WEST SUSSEX COUNTY COUNCIL CONSULTATION

TO:	Arun District Council FAO:Karen Garner
FROM:	WSCC - Highways Authority
DATE:	13 August 2019
LOCATION:	Nyton Nursery Bungalow Nyton Road Chichester PO20 3UQ
SUBJECT:	AL/50/19/DOC Approval of details reserved by condition imposed under ref APP/C3810/A/14/2217385 (AL/61/13/) relating to Conditon No 12 - secure cycle parking.
DATE OF SITE VISIT:	n/a
RECOMMENDATION:	No Objection
S106 CONTRIBUTION TOTAL:	n/a

DRAWING TITLE: SITE LAYOUT PLAN

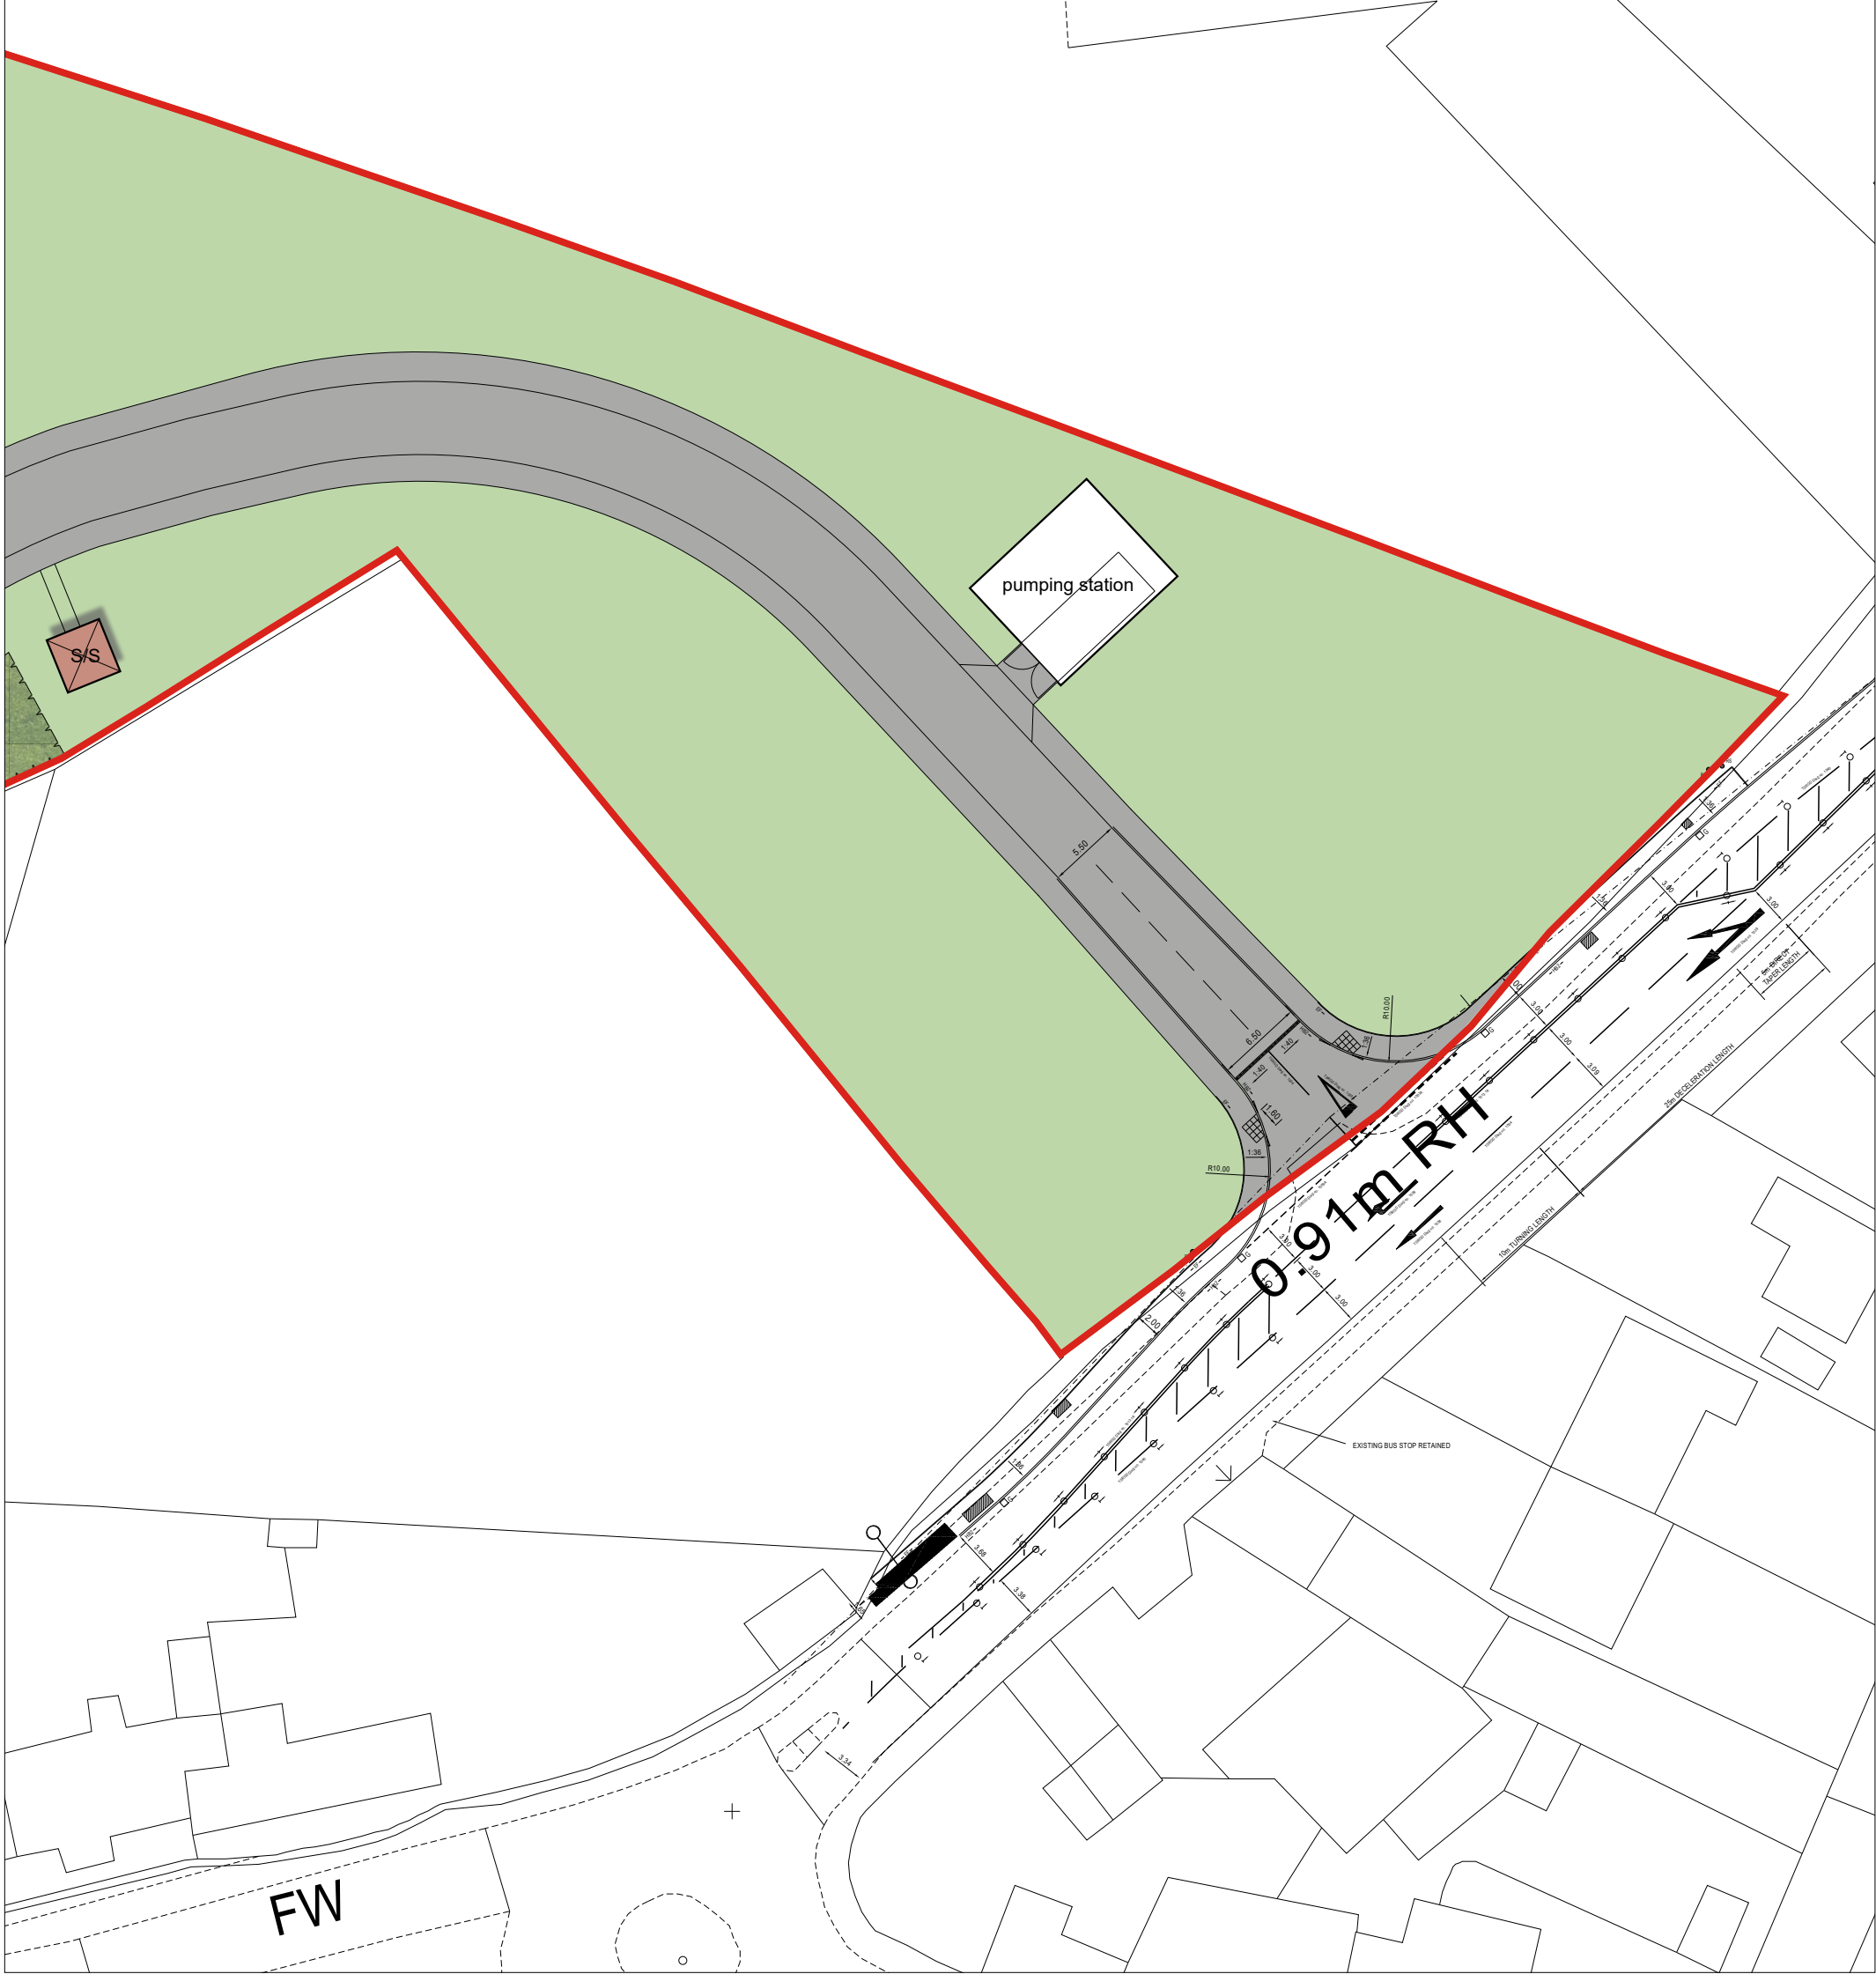
The proposed details show a mix of cycle storage provision. For those houses with garages, the expectation is that these will be used to satisfy the condition requirements. For those houses without garages, a separate store is to be provided. Again, these satisfy the requirements of the condition. The only aspect that doesn't appear to be covered is cycle parking for the flatted units. Details for these units should therefore be provided.
